DESIGN BRIEF- 3055 Richmond Road

2022-10-06

Proposed 4 Storey Residential Building

COMMENTS and RESPONSES from PRE-CONSULTATION with CITY PLANNERS

DRAWING NAME: SOUTH ELEVATION

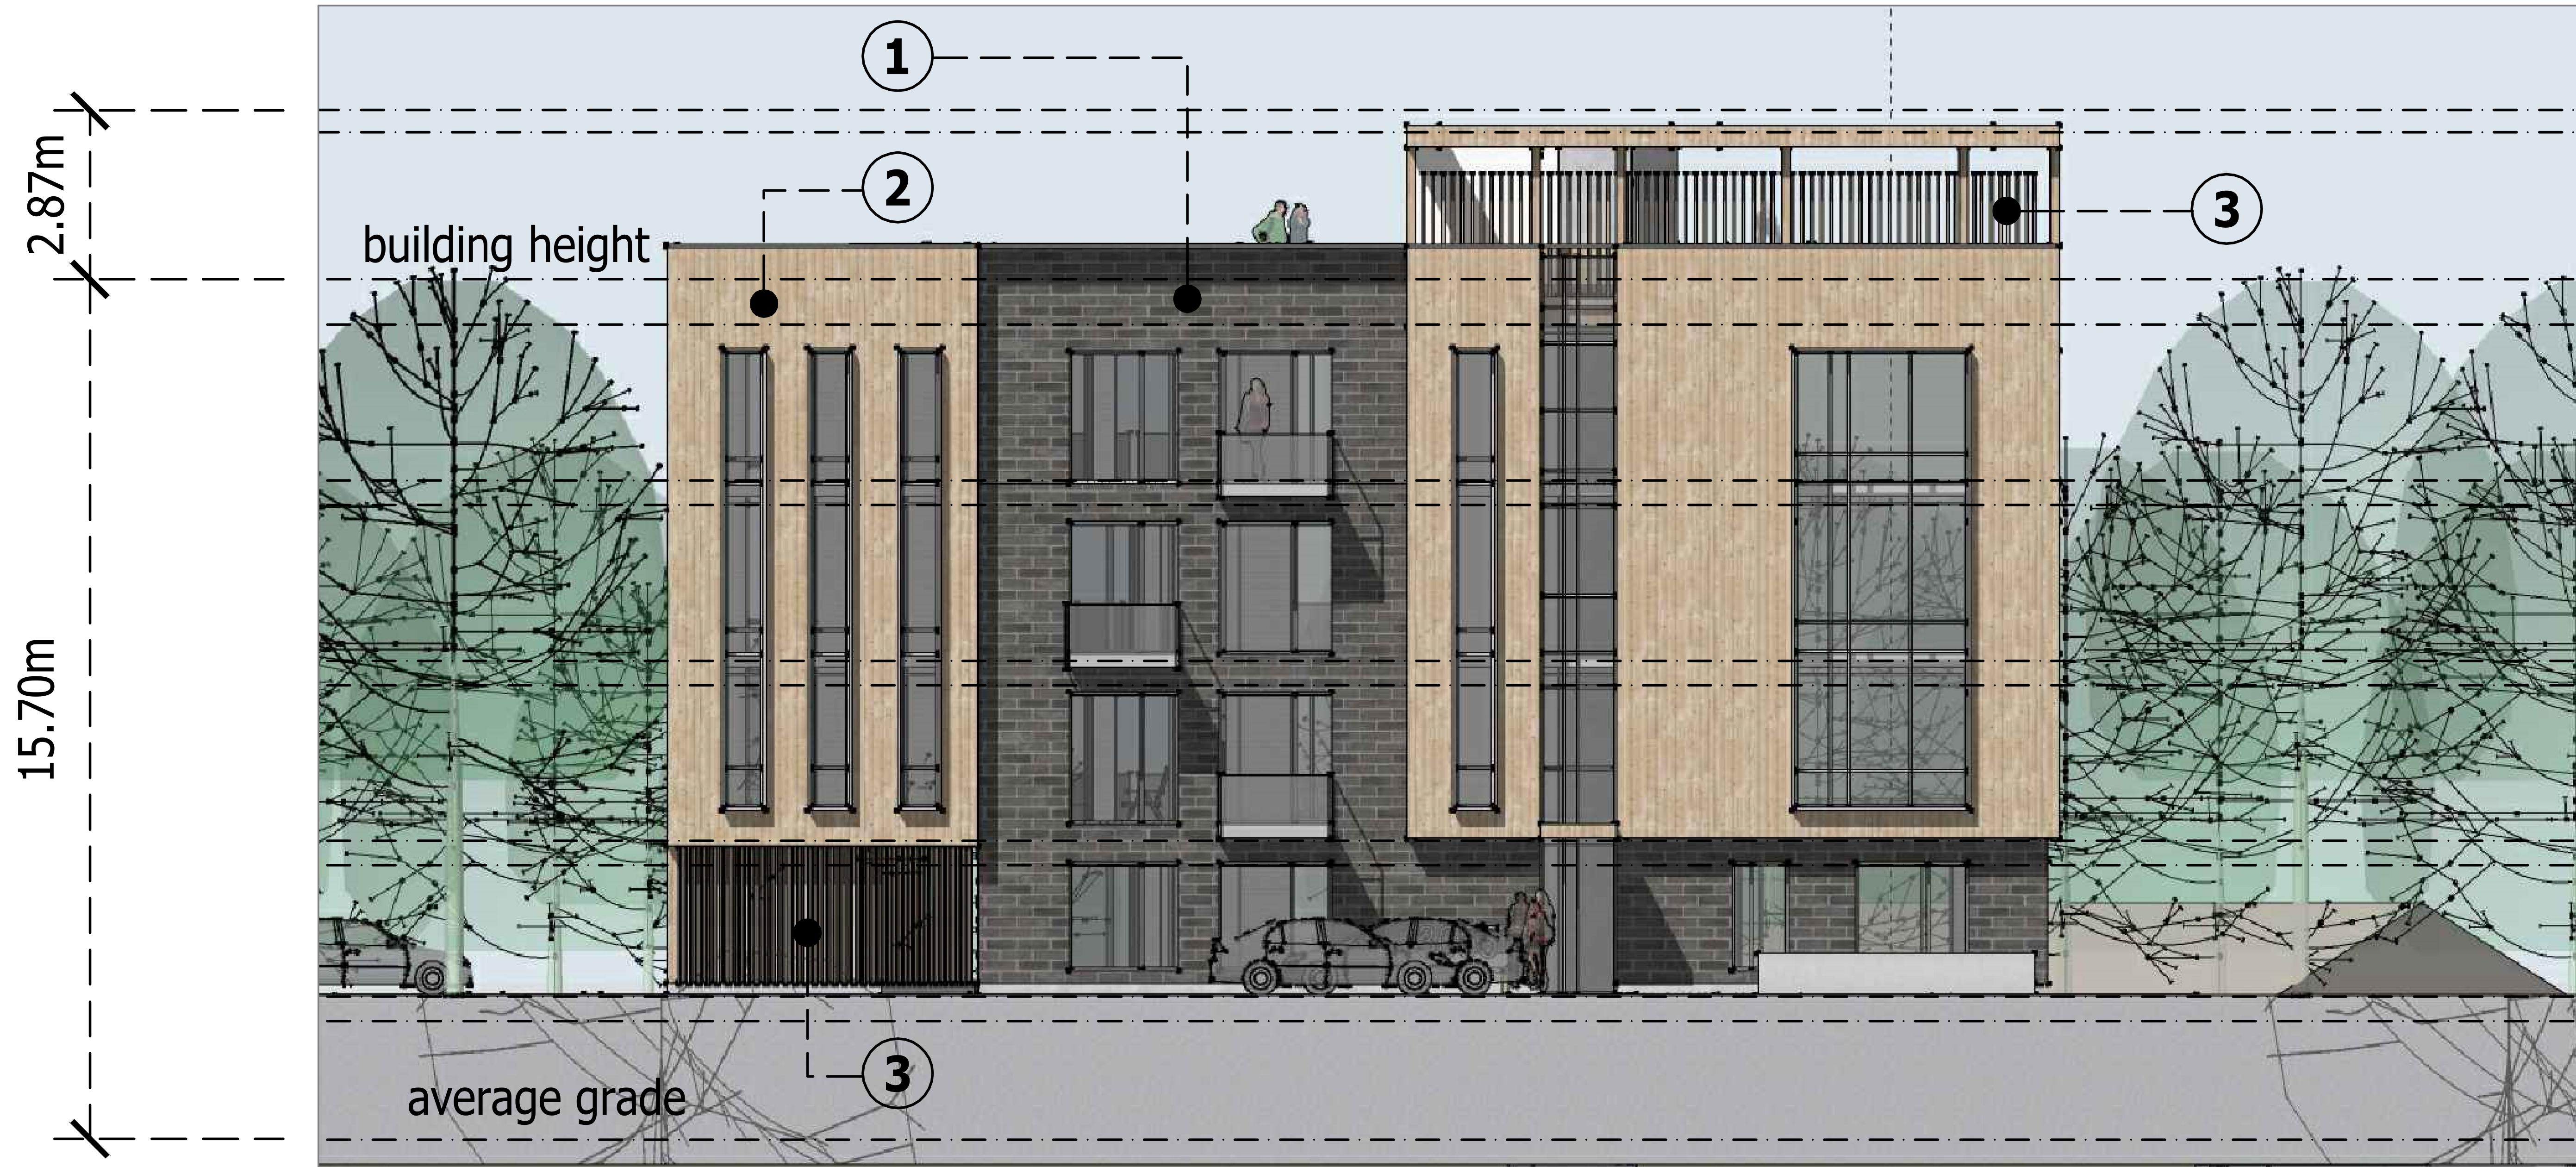
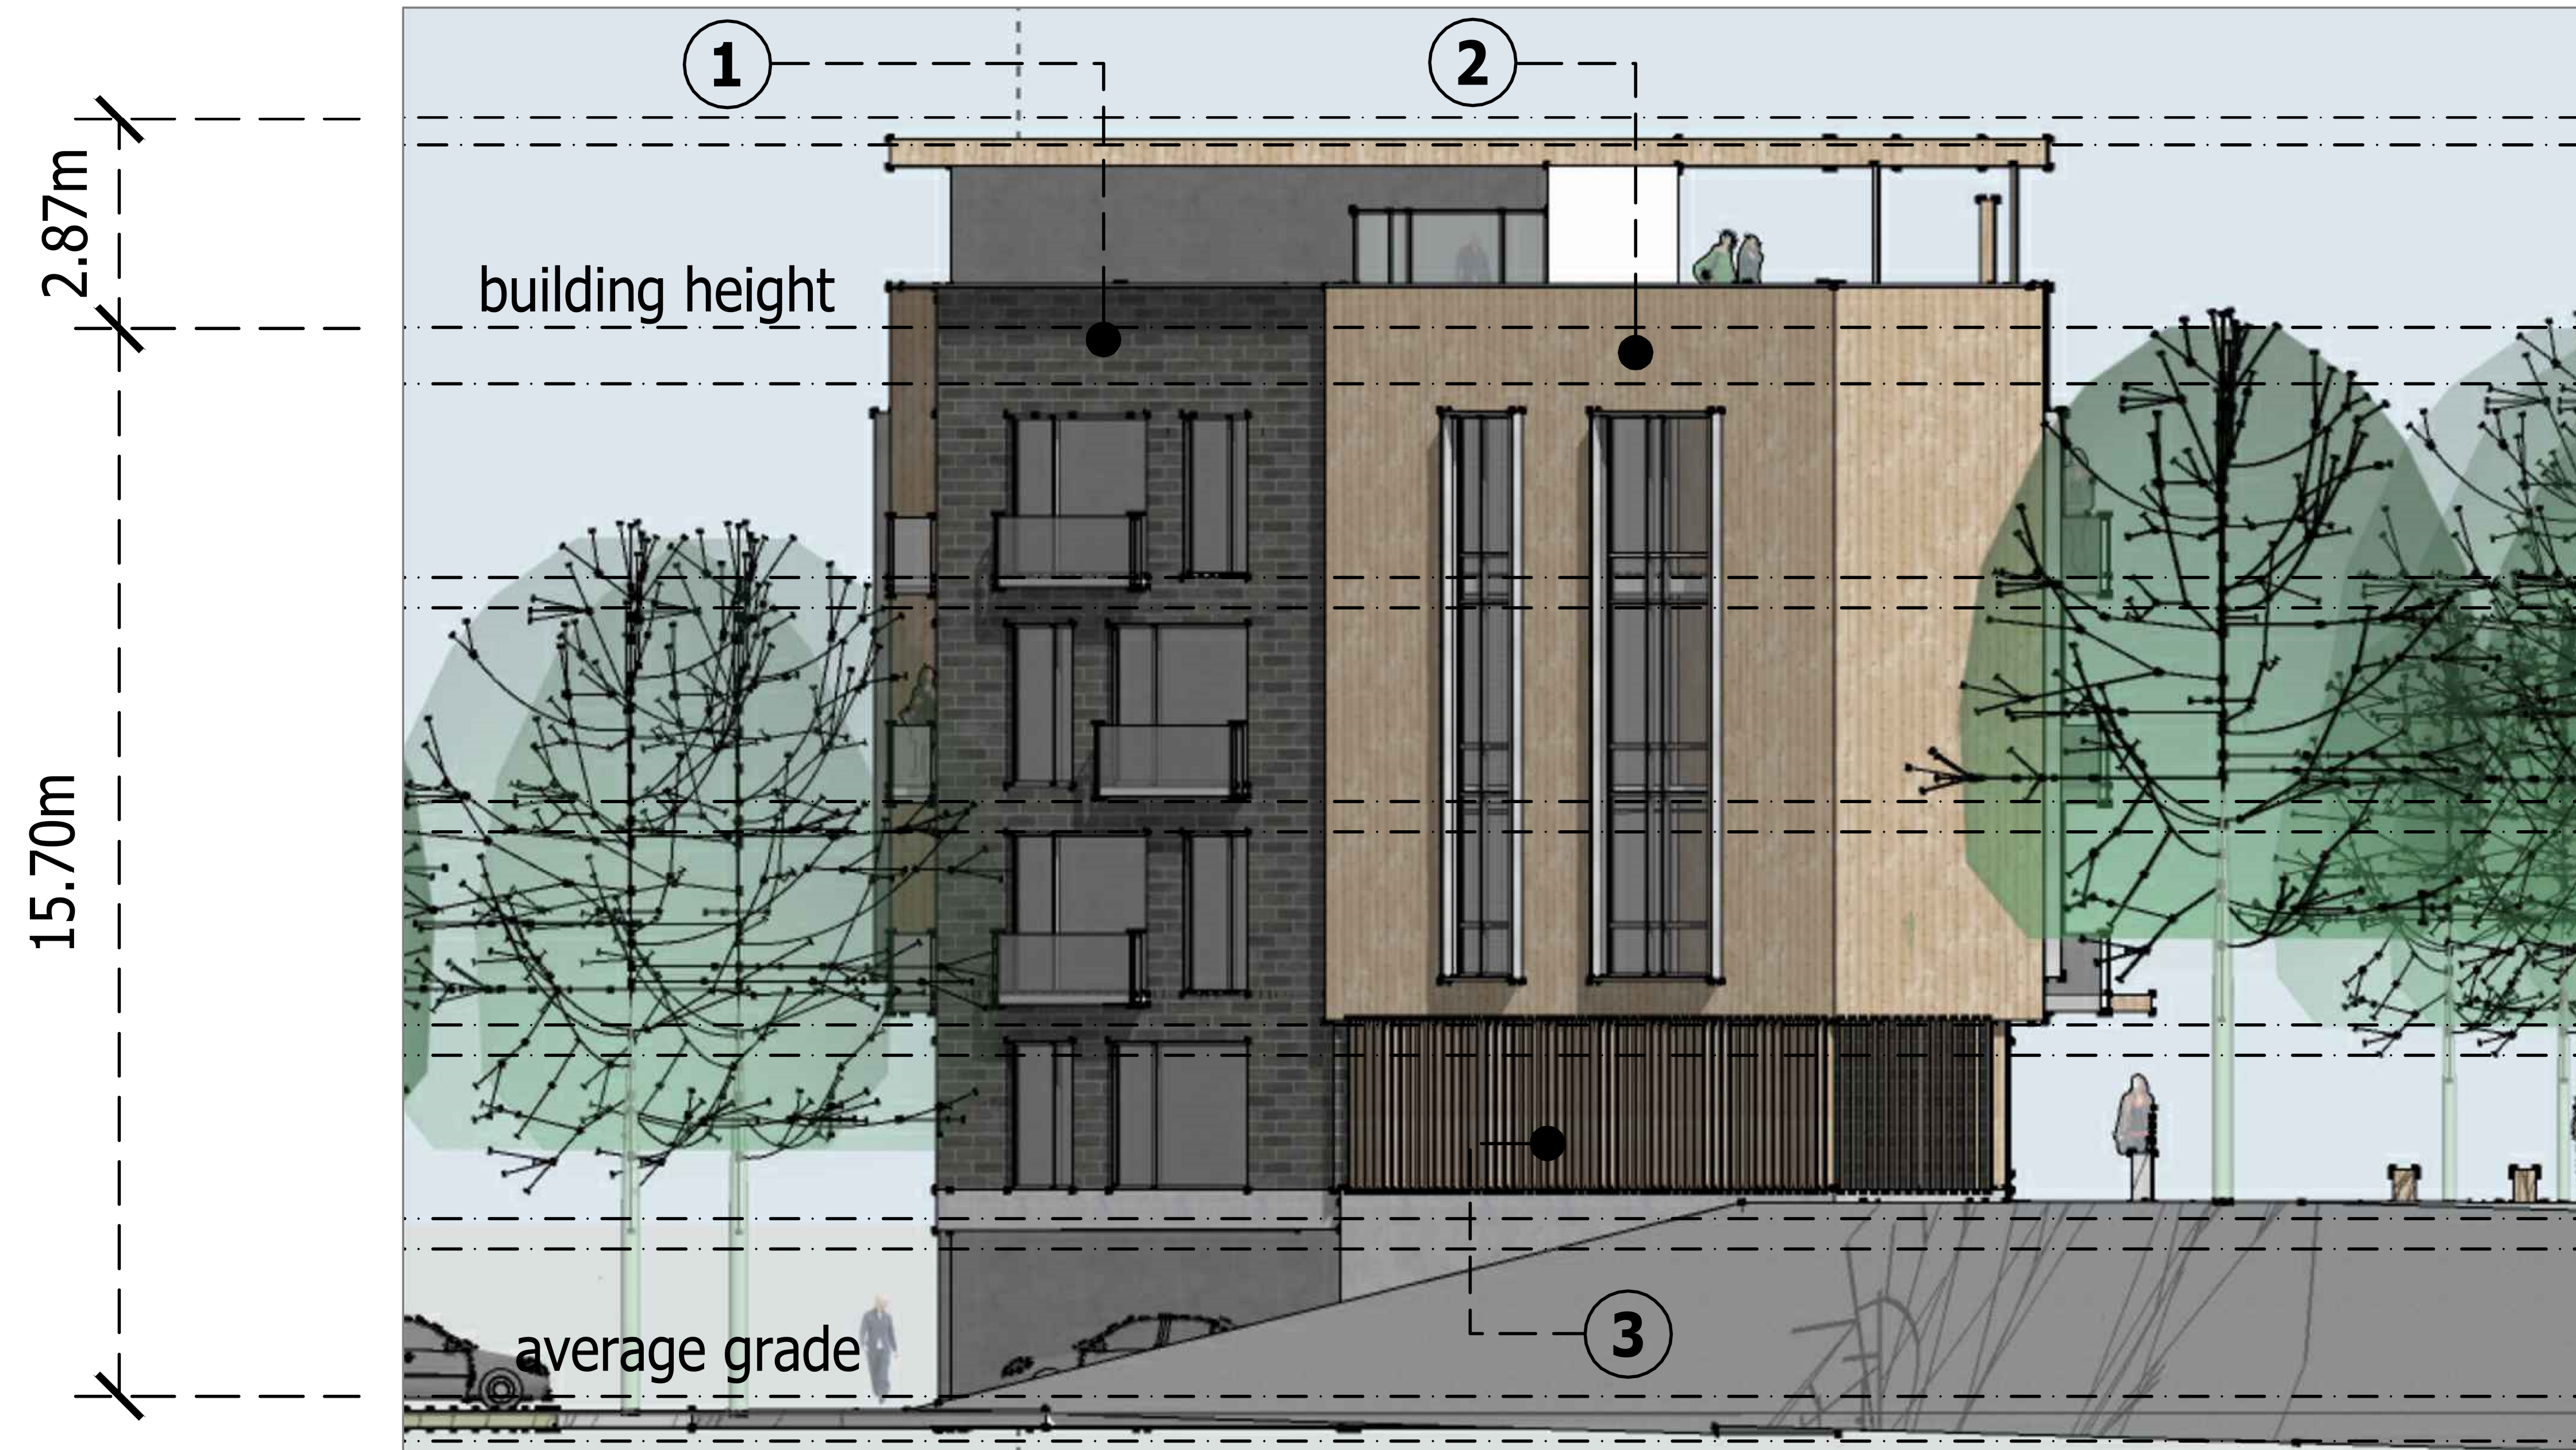
Comment: *There is some concern with the projecting balconies indicated on the It is recommended to use inset balconies facing street as detailed on the perspective drawing shown at the pre-consultation.*

Response: Balcony positions and architectural language has been changed. We're against providing inset balconies as these foster occupants to use them as covered storage, our balconies remain proud of the building, enclosed in glass guards, and are staggered in an irregular fashion as part of the vision and architectural language. They are intended to 'lighten' the facade.
